Your Ref: MP05_0129
Our Ref: S09/0034
DA09082762707 PC

15 April 2013

**Preferred Project Report, Lakes Estate Residential Subdivision, North Boambee Road,
North Boambee Valley (MP05_0129)**

Image 08: Access arrangements for Stages 3b

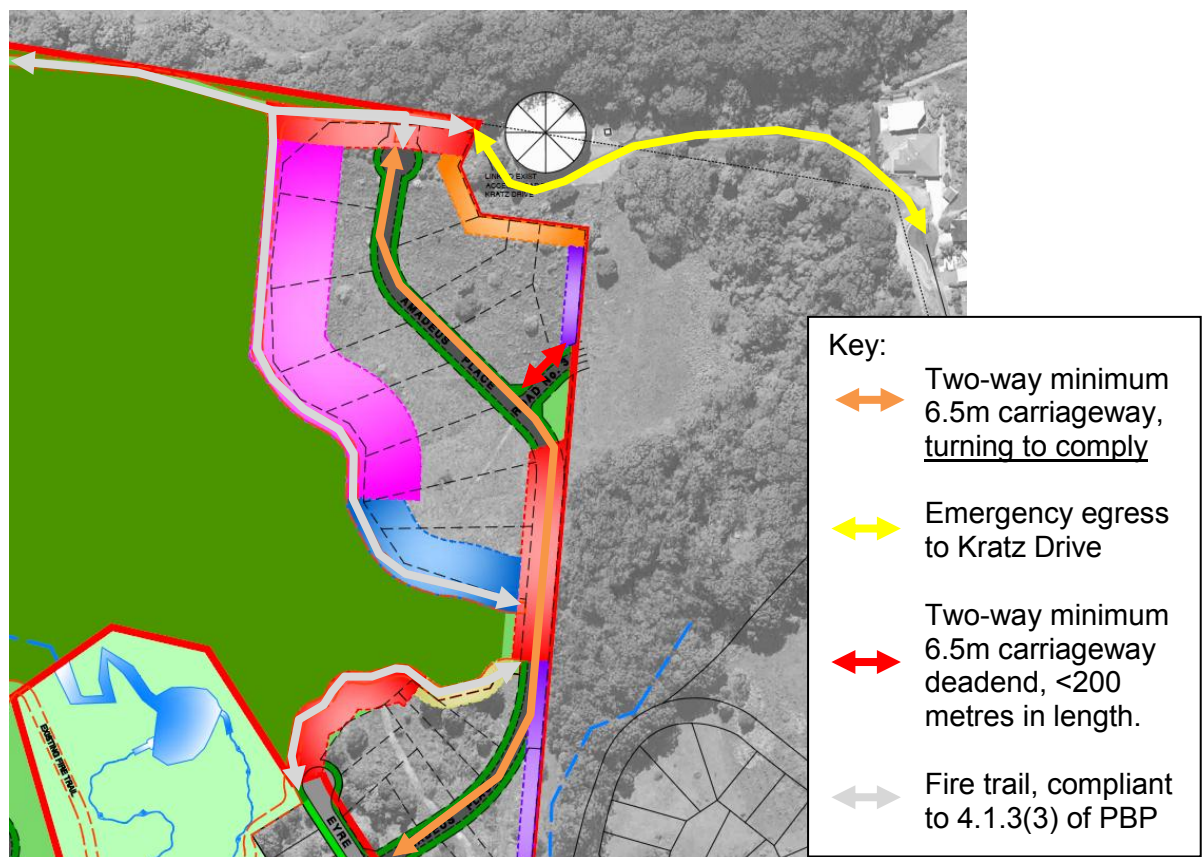
Stage 3b includes a proposal for emergency access from the northern end of Amadeus Place to Kratz Drive via a proposed fire trail and extension of the existing service road to Roberts Hill Reservoir. No details have been provided to the RFS to demonstrate that the owner of the land on which the proposed emergency access route will be located as provided consent for the creation of the emergency access, or that the subject land is included as part of the development application. Provision of emergency access from Amadeus Place to Kratz Drive is essential for the safe development of Stage 3b and as such, the RFS does not support the granting of consent for Stage 3b until the above matter is resolved.

13. Prior to issue of a subdivision certificate for Stage 3b a restriction to the land use pursuant to section 88B of the 'Conveyancing Act 1919' shall be placed over the emergency access from the northern end of Amadeus Place to Kratz Drive. The emergency access shall be constructed in accordance with the requirements of section 4.1.3 (3) of 'Planning for Bushfire Protection 2006'.

A017

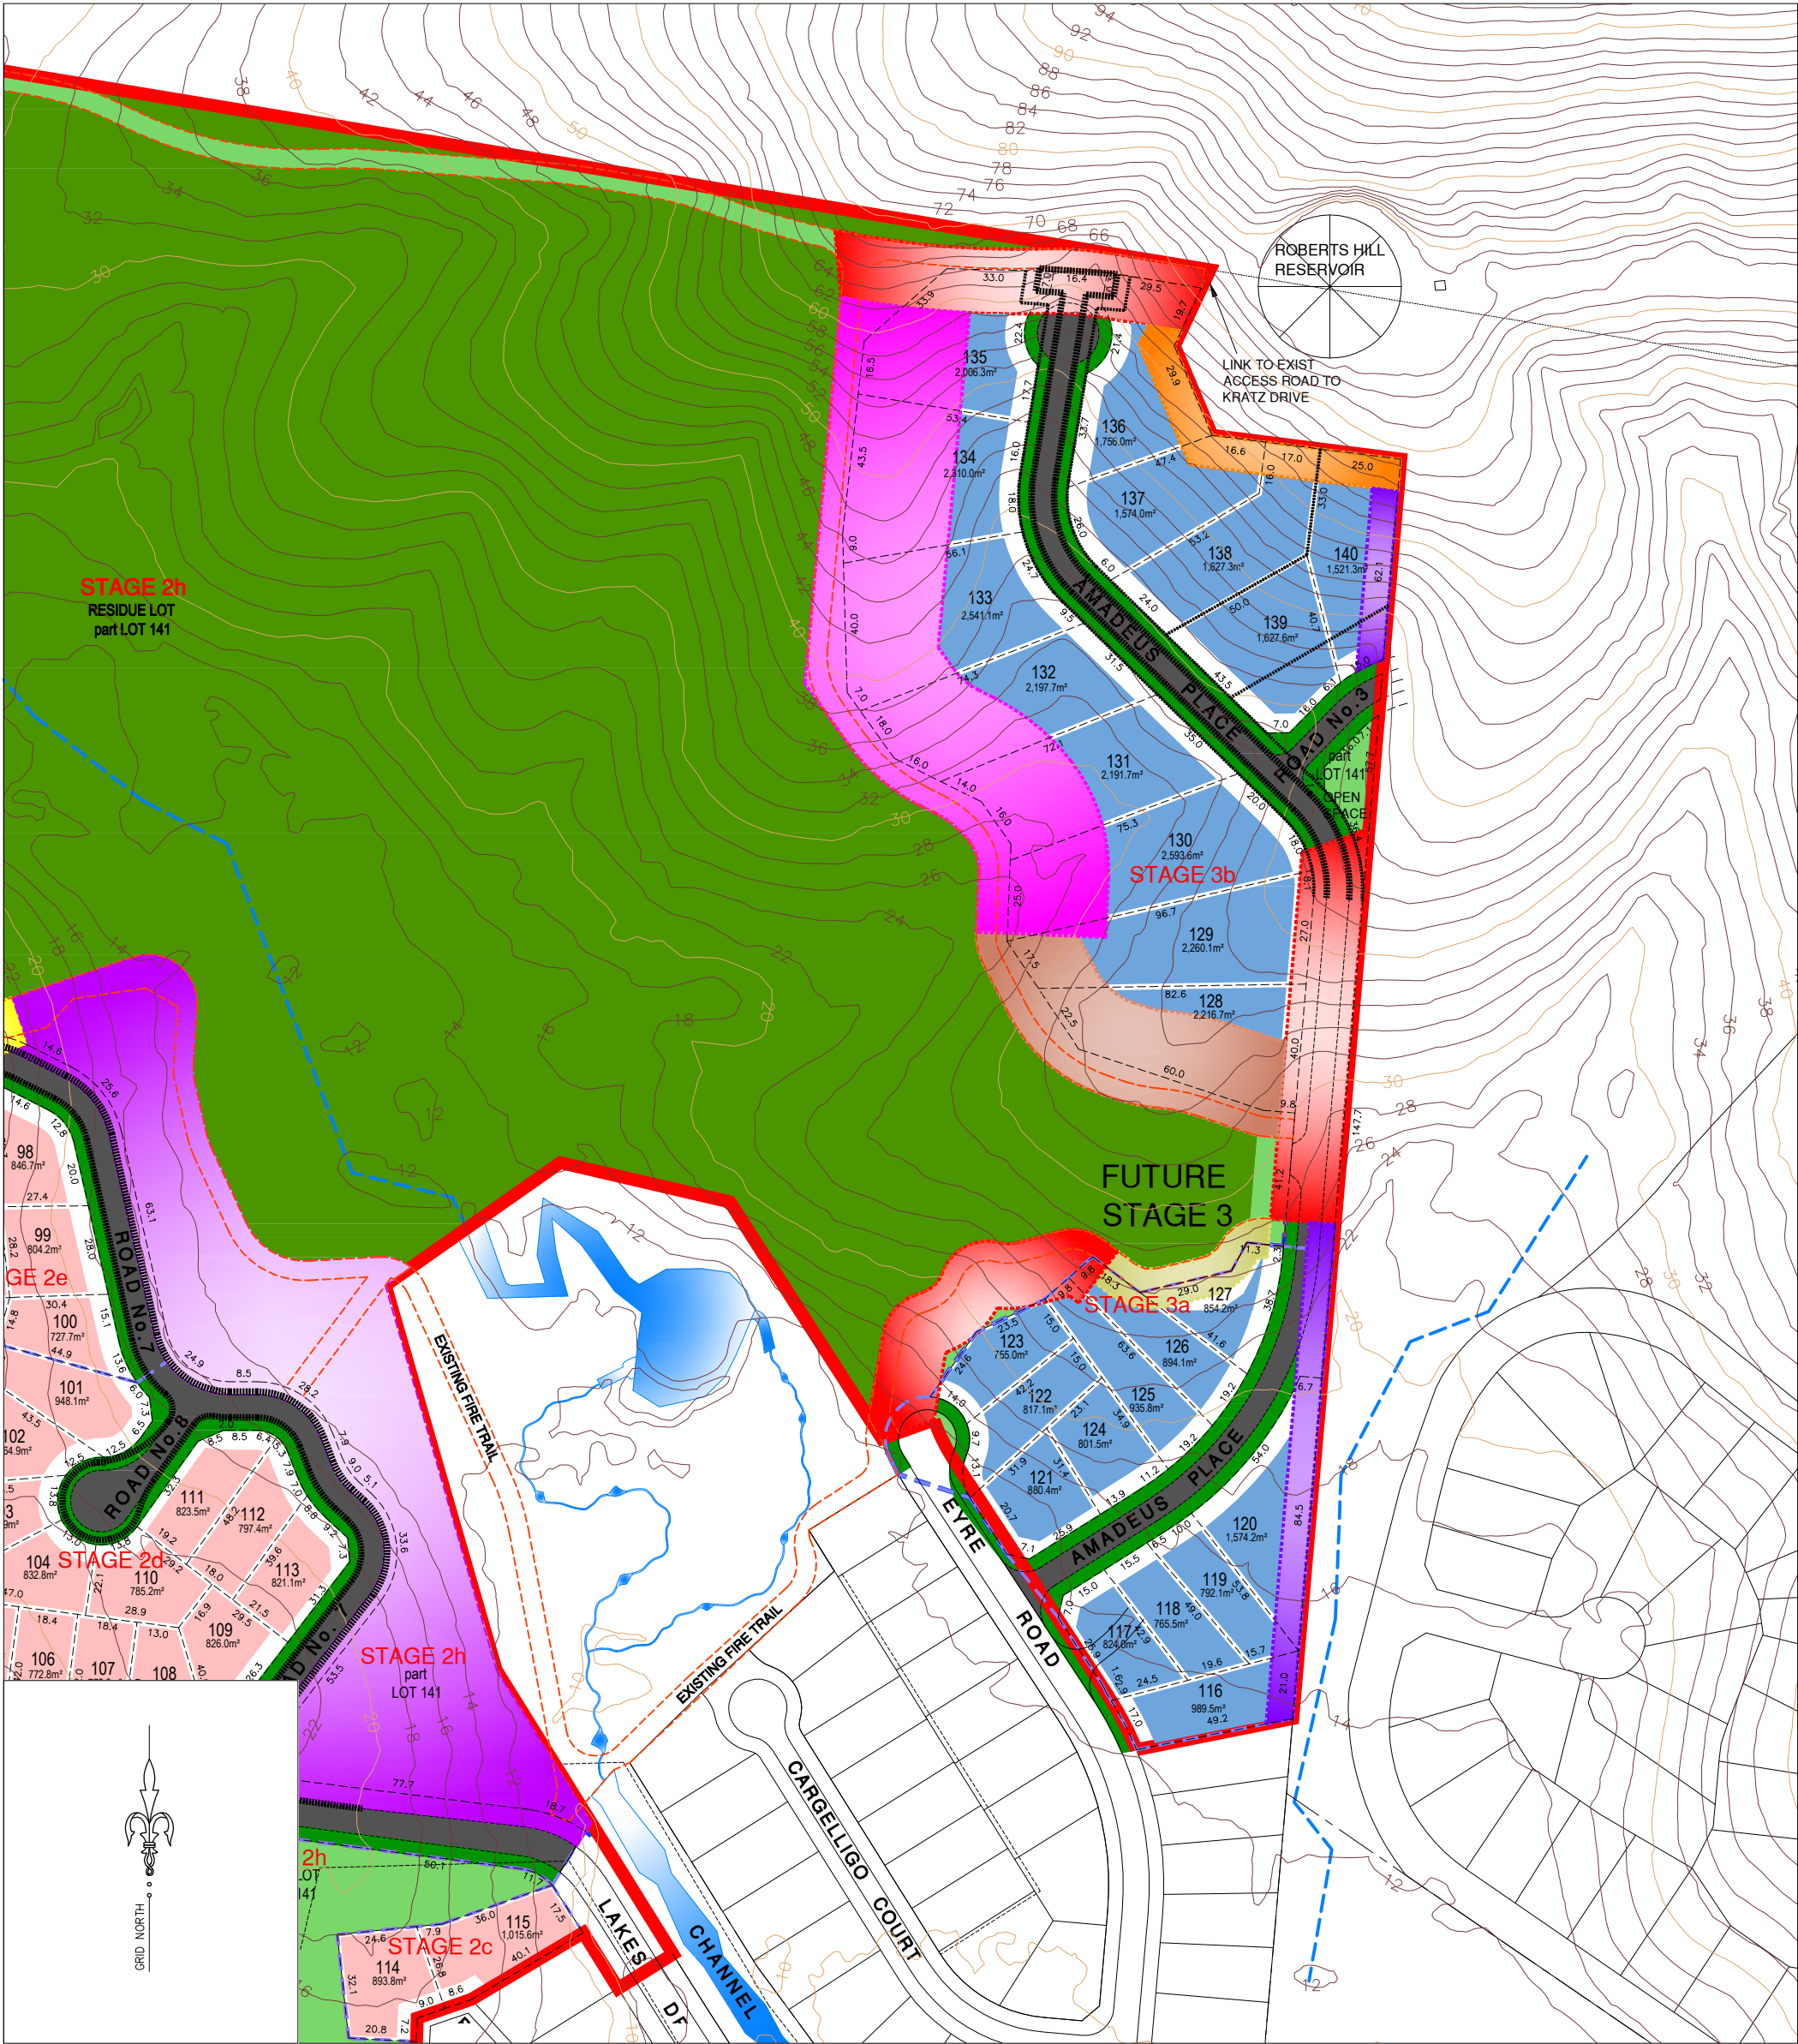
1. The development proposal is to comply with the subdivision layout identified on the following plans prepared by Astoria Group Pty Ltd (hereafter referenced as the 'approved plans'), except as modified by the following conditions:

Subdivision Stage 2 Plan – Response to RFS (Project No. 912, DWG No. A017
(Revision A), dated 11 March 2013

- a) APZ over the southern portion of Lot 67 being increased to 9 metres;
 - b) APZ over the southern portion of Lots 73, 74 and 75 being increased to 21 metres;

- c) include a 10 metre wide APZ along the eastern boundary of Lot 88 - measured from the western edge of the unmanaged vegetation;
 - d) include a 10 metre wide APZ over Lot 142 along the western edge of Lot 76;

- e) APZ over the eastern portion of Lot 120 being increased to taper from 9 metres wide at the south to 12 metres wide at the north;
 - f) APZ to the north-west of Lot 123, 125 and 126 being increased to 21 metres; and

- g) APZ over the northern portion of Lot 127 being increased to 13.5 metres;
4. The required s.88B restriction along the western boundary of Stages 1b, 1d and 2a, and along the eastern boundary of Stage 3b, may be deleted following the commencement of development on the adjoining land that removes the grassland hazard.
